CITY OF ALBUQUERQUE

May 1, 2014

**RE: Property located at 1441 Woodward Rd. SE
Albuquerque, NM 87106
Retaining wall concerns
File: M15D23B**

RETAINING WALL PROFILES

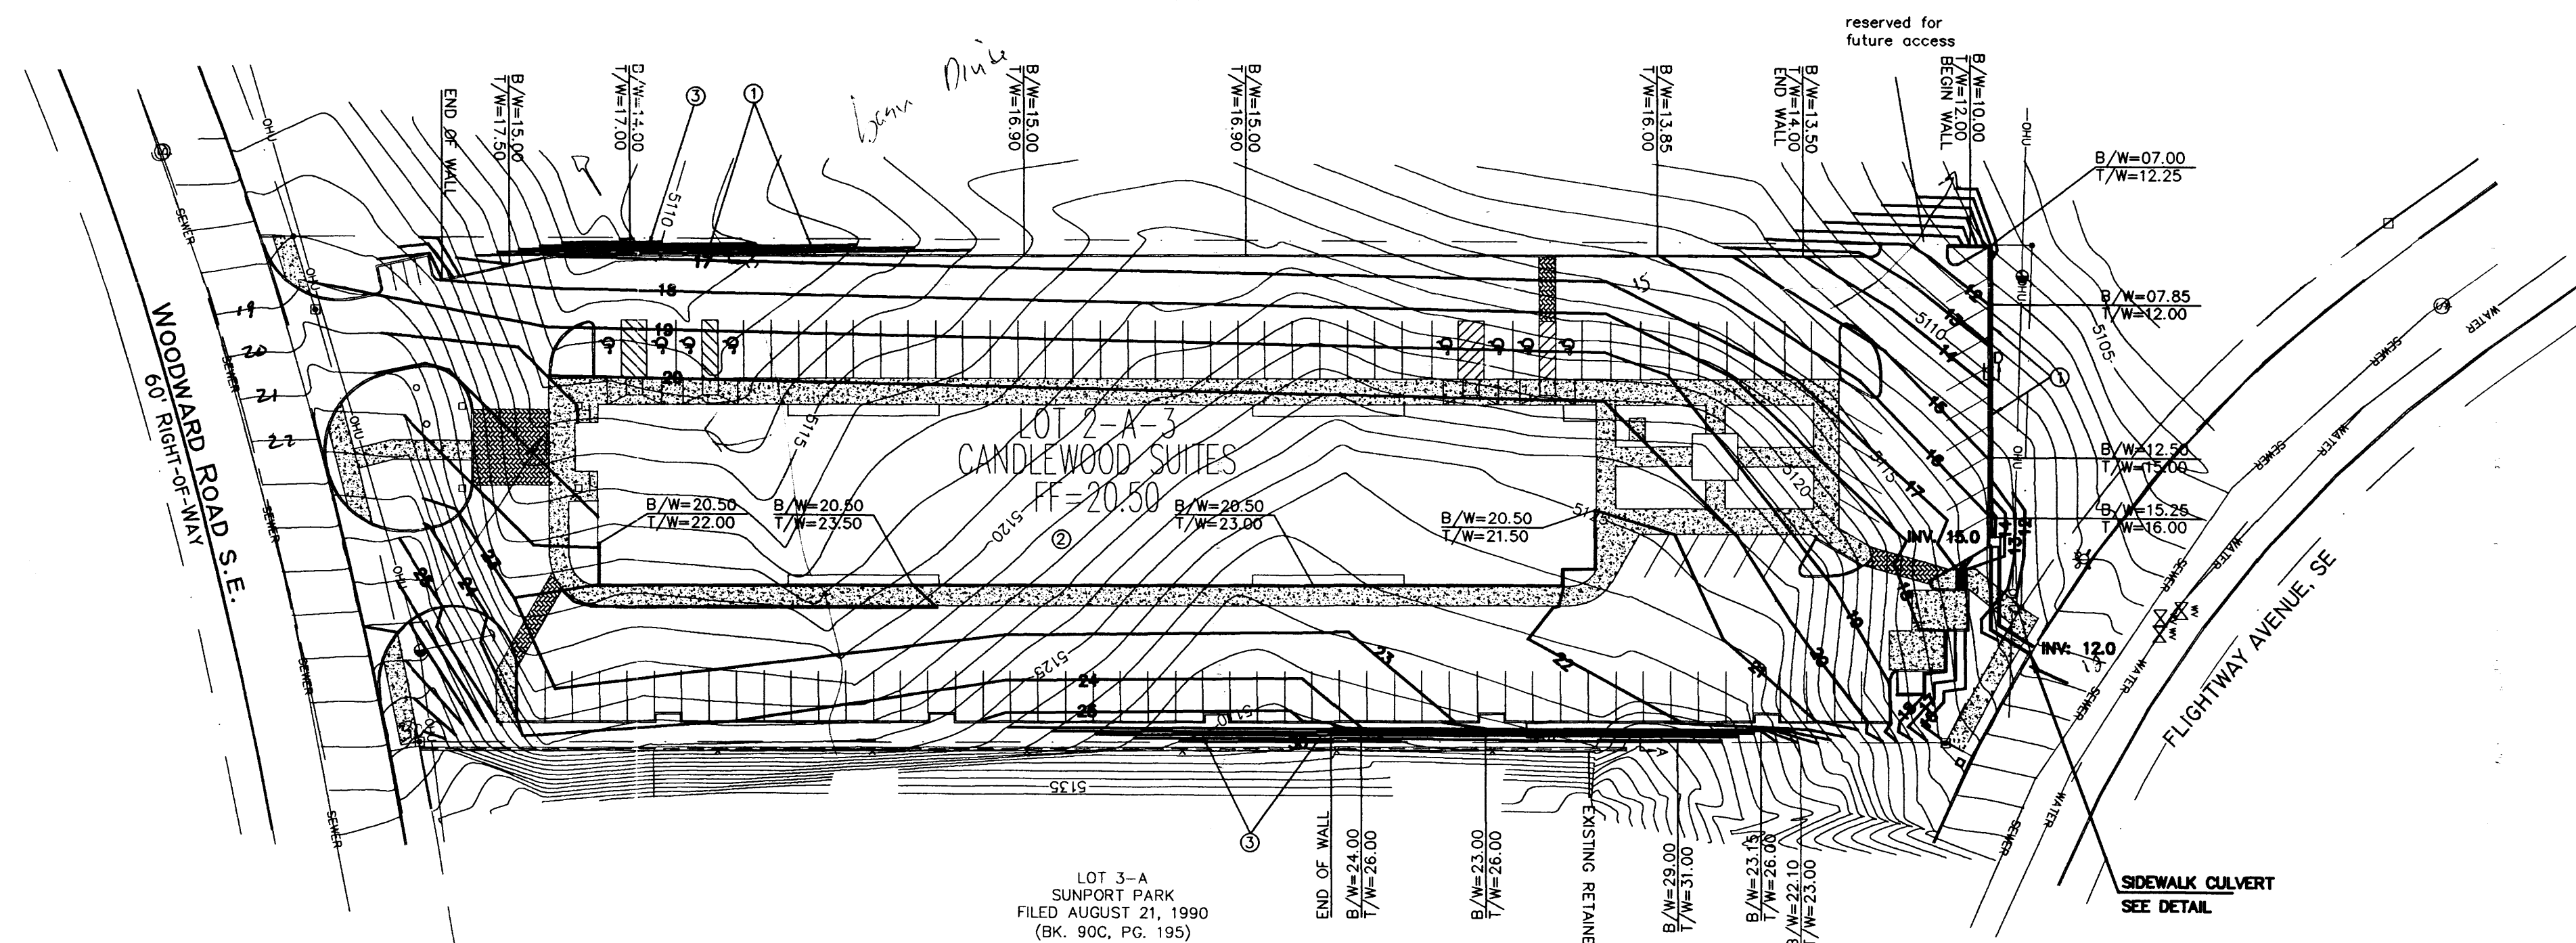
It has recently been brought to the attention of the City of Albuquerque's Development Review Services that the above referenced property has been graded. There is concern that the retaining wall on the adjacent property may be compromised. Retaining walls may rely on soils beyond the footing for stability and soil bearing in their design. Without proper understanding of the structural mechanics of the wall, removal of the soil may cause soil overbearing and/or overturning failure of the wall. Furthermore, slopes typically do not exceed a 3:1 ratio without any slope treatment. A photo of the retaining wall is included in this correspondence.

We do not have in our records an approved grading plan as is required pursuant to City Ordinance §14-5-2-12 (B)(2). Therefore, the soil cut shown in the photo is not approved by the City. It is incumbent upon the property owners to verify that the integrity of the wall is not compromised, or to regrade the property such that the risk of failure of the retaining wall is minimized. Grading a lot 1 acre or more requires a Grading Permit pursuant to the above mentioned ordinance.
